Ref: 221021\_Let2\_Rev1

14 September 2022

**Re: 57 Station Road, Seven Hills – 19.2MW Two Storey Data Centre – DPE Response**

This letter provides a response to DPE's comments regarding the Air Quality Impact Assessment for the proposed development located at 57 Station Road, Seven Hills, also described as Lot B in DP 404669. The proposed development is for a 19.2MW two storey data centre.

Figure 7-12: Isoleth for NOx – 100th Percentile (without background)

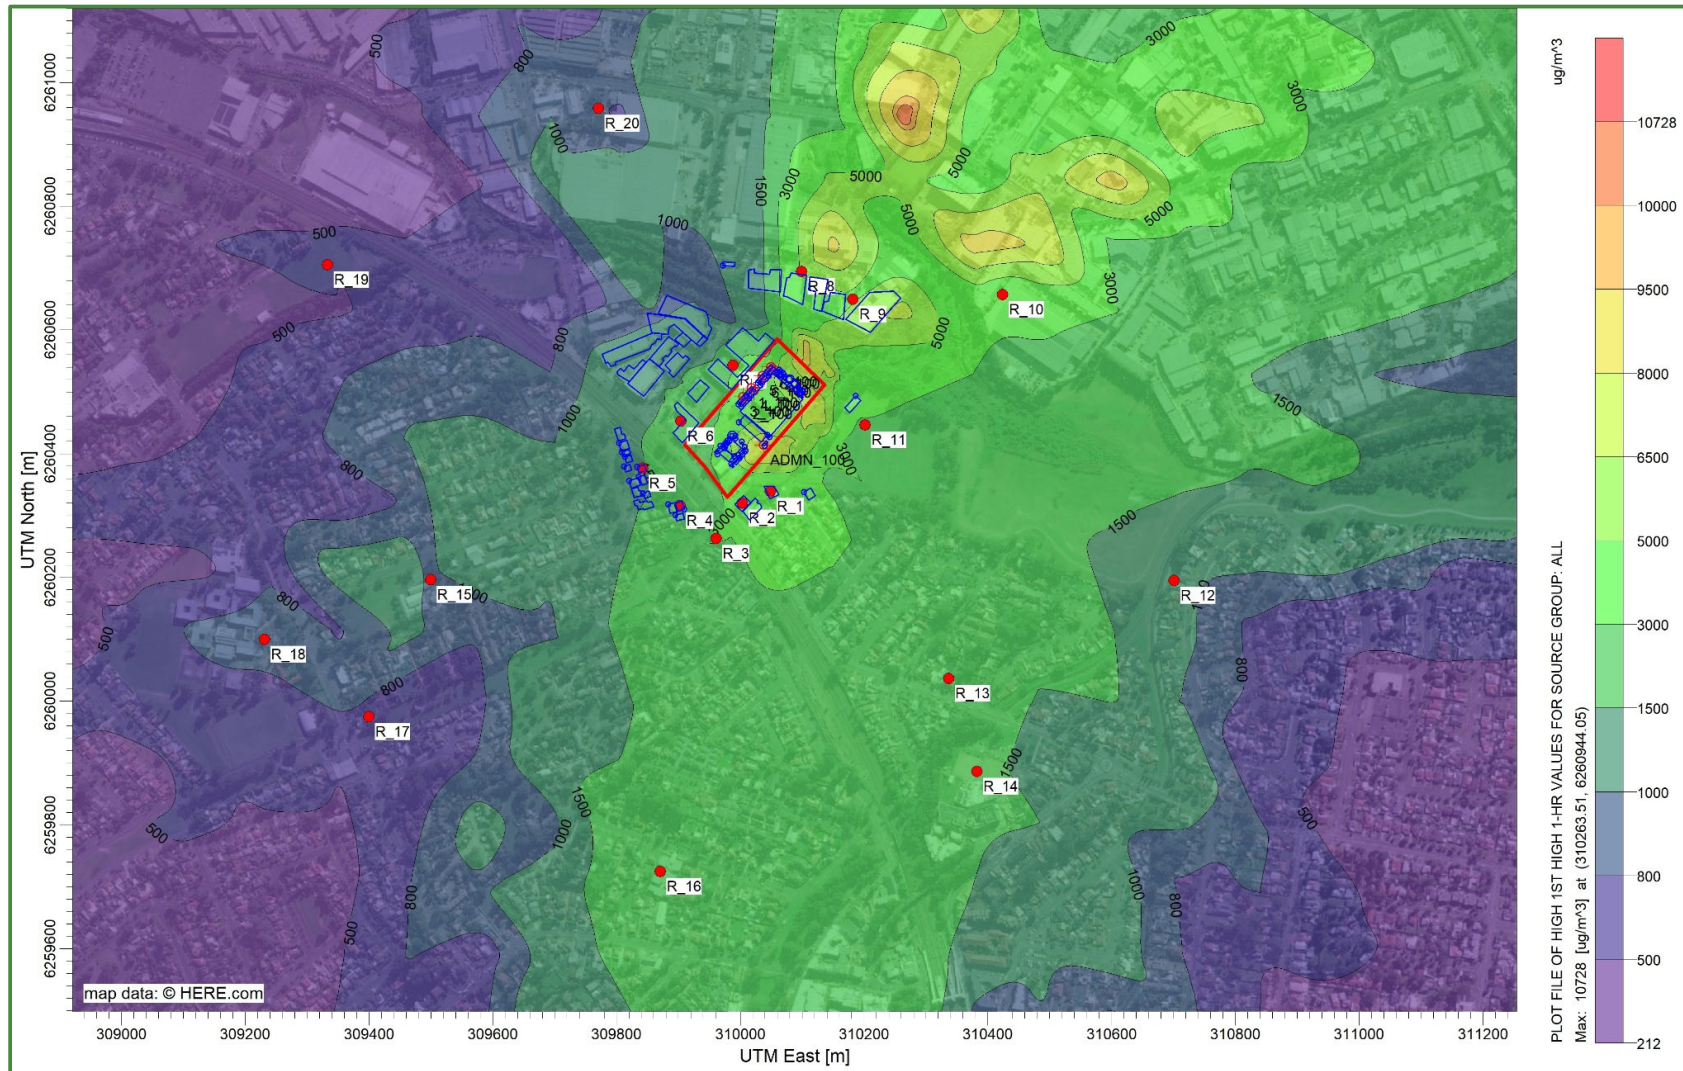
*7-The Department notes the submitted air quality impact assessment does not appear to have adequately considered cumulative impacts associated with the Council-approved development to the front of the site. The modelling (particularly Scenario 3 - Emergency operations) should subsequently be updated to address this matter.*

With the inclusion of the three additional generators from the already approved data centre the total NO<sub>x</sub> emissions are expected to increase in Scenario 3 by approximately 20%. As shown in the assessment the Scenario 3 of the assessment, the predicted ground level concentrations of NO<sub>2</sub> of the emergency scenario exceed the criteria for the 100th percentile. It is important to note that Scenario 3 assumes each all generators are operating 100% of the time, therefore a 100th percentile is highly conservative. Based on the system average interruption duration index (SAIDI) and the system average interruption frequency index (SAIFI), a supply loss of ~350 minutes represents 0.069% of the year. Based on this, despite predicted exceedances of the NO<sub>2</sub> impact assessment criteria being likely during operation of all standby generators concurrently, it is not likely that this worst-case scenario would occur in a typical year. A cumulative assessment of 12 generators running at 100% capacity (emergency scenario) would not alter the outcomes of this assessment. Therefore, we believe additional modelling is not considered warranted.

The certain circumstances in which the development would cause additional exceedances are unlikely. There is difficulty in the direct application of the additional exceedance criteria for emergency generators as they are not in operation unless during maintenance or in the event of a power outage representing a very small amount of time over the course of a year. Furthermore, the Approved Methods do not contain methodology for the assessment of infrequent operations with a risk-based consequence and frequency criteria for further assessment. Therefore, additional assessment is not considered warranted.

Note: The 20% increase in emissions has been estimated by calculating the emission rate for the existing generated using a normalised exhaust concentration 4,140 mg/m<sup>3</sup> for the Cummins2250 generator and an exhaust flow rate of 5.6 m<sup>3</sup>/s and 1.37 m<sup>3</sup>/s for the Cummins2250 and Cummins550 generators respectively then correcting for a dry exhaust flow using a typical factor of 0.35 and calculating the percentage based on the total mass emission rate of these 3 generators compared with the total mass emission rate of the proposed facility.
